**Section 96A of the Town & Country Planning Act 1990 (as amended)
Town and Country Planning (Development Management Procedure) (England) Order 2015 (as amended) - Article 10**

Non-material amendment following the grant of reference AW/359/18/HH to increase the width of extension by a further 800mm to the south.

30 Gossamer Lane Aldwick PO21 3BY

Drg No.: SBS/508/05 A

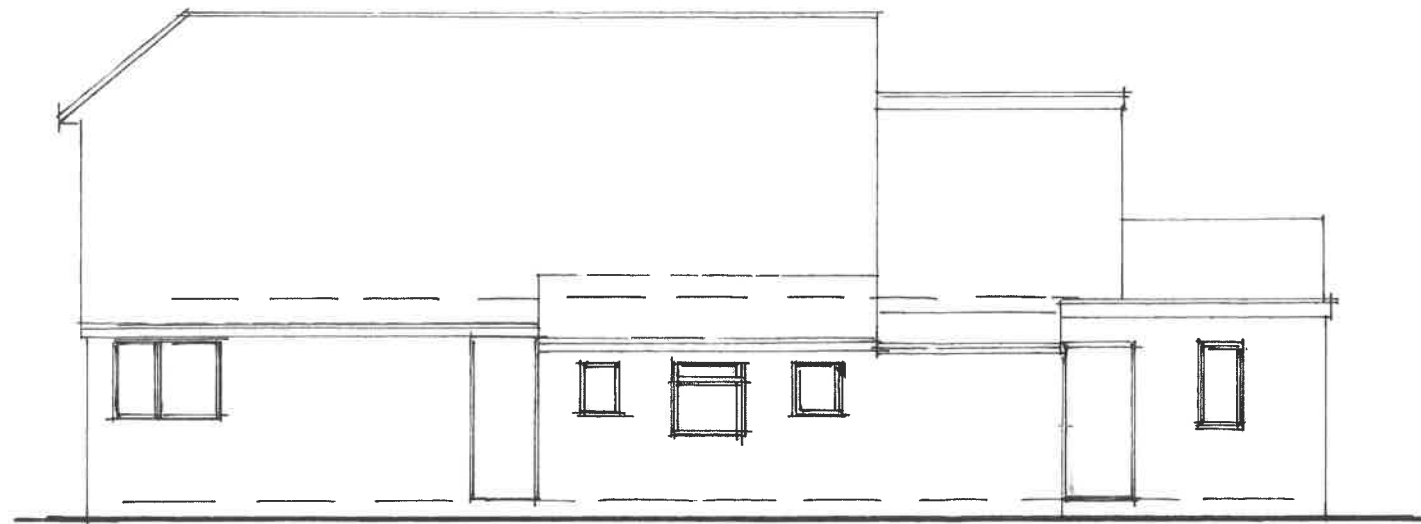
- Existing and Proposed Roof Plan - SBS/508/07
- Proposed Ground Floor Plan - SBS/508/03 B
- Existing and Proposed Elevations - SBS/508/05 A

These plans are accepted as a Non material amendment and now become the approved plans for AW/359/18/HH.
